ELECTRICAL PERMIT

LOCATION: 710 Forest Avenue METER MAKE & # _____
CMP ACCOUNT # _____ OWNER Tahbar Essa 3 Riverton drive
TENANT _____ PHONE # 615-4369

Brian Laflamme - 710 Forest Avenue

From: Brian Laflamme
To: Hec2980@yahoo.com
Date: 5/9/2012 2:50 PM
Subject: 710 Forest Avenue
CC: Donald McPherson; Jeanie Bourke; John Martell

3 SITE LIGHTING PHOTOMETRICS PLAN
L3.0 SCALE: 1" = 10'

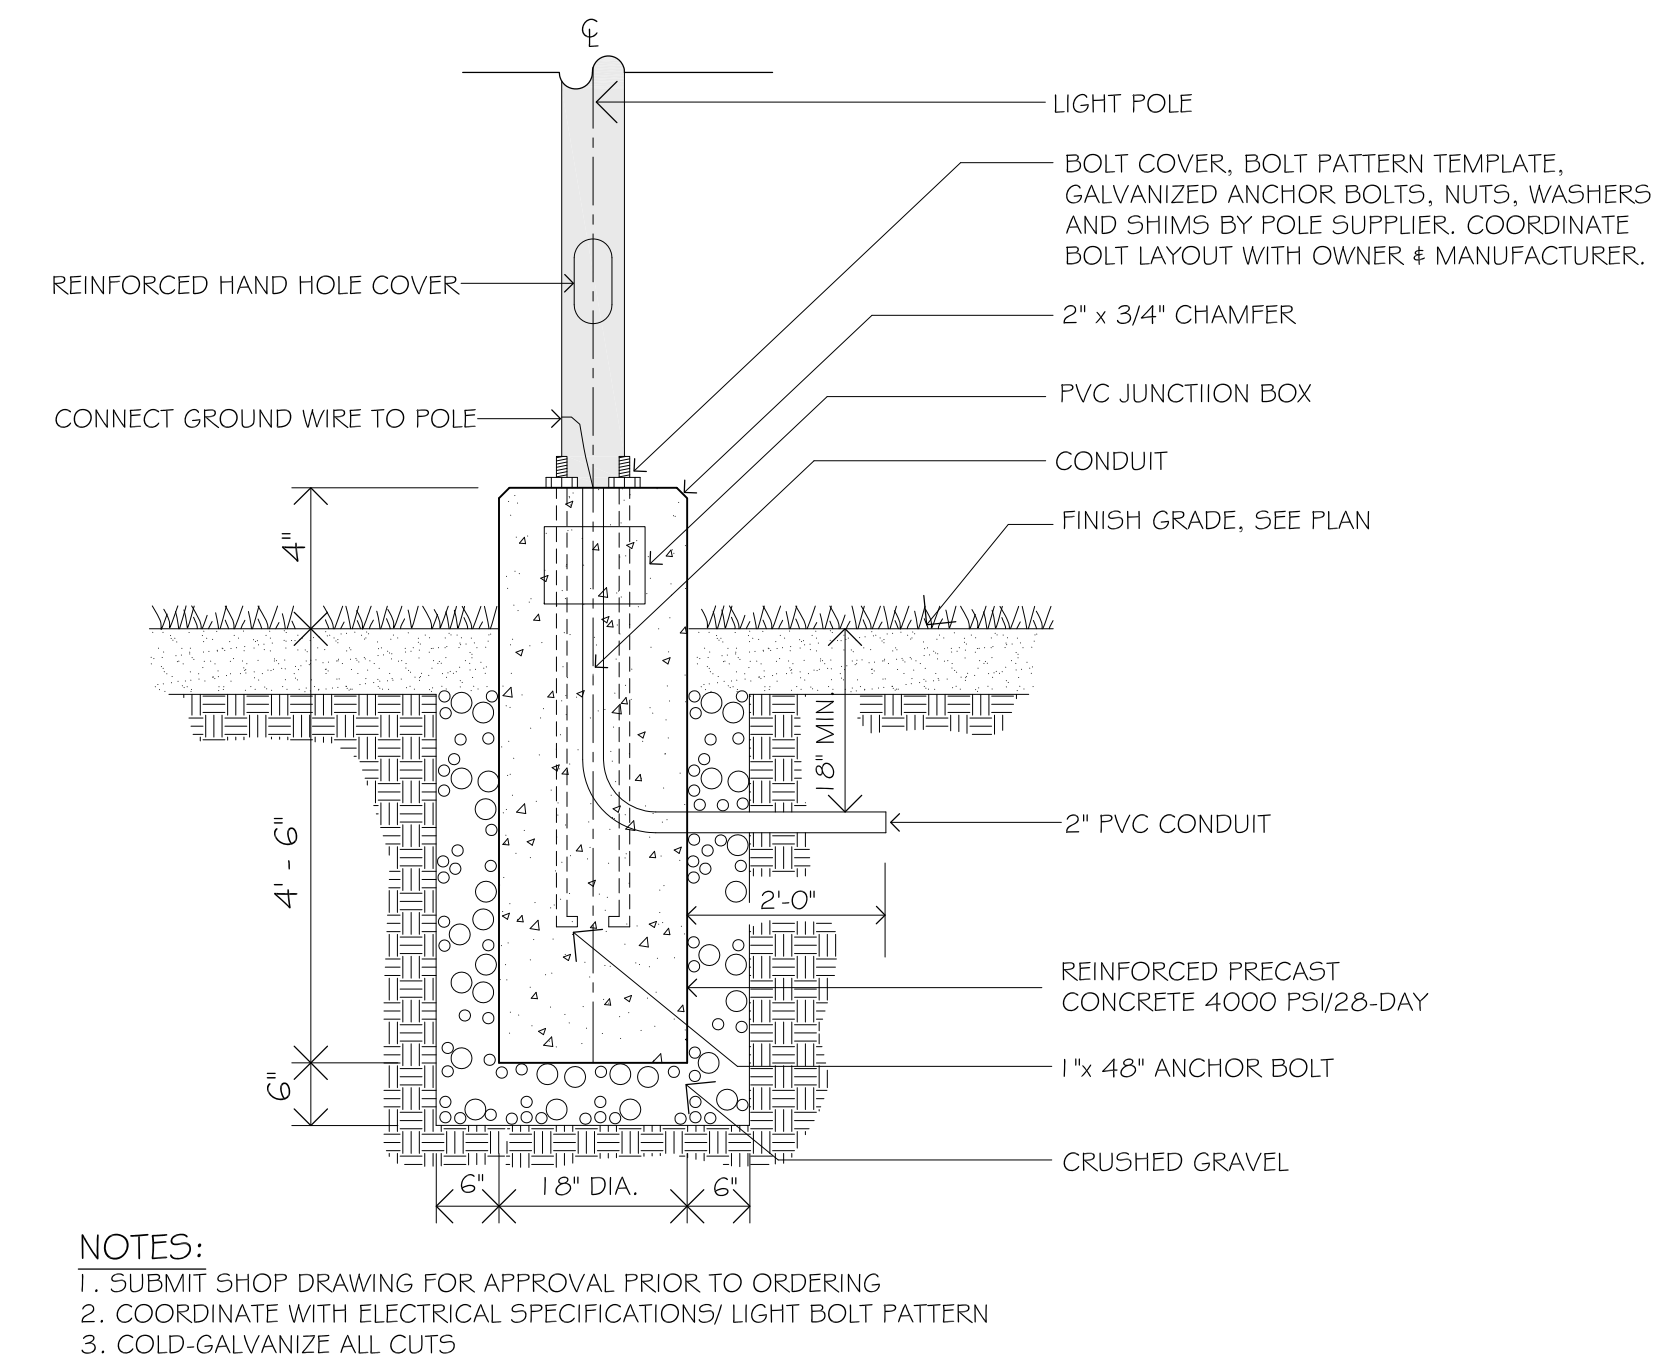
Parking lot lighting was never inspected for wiring or trench inspection
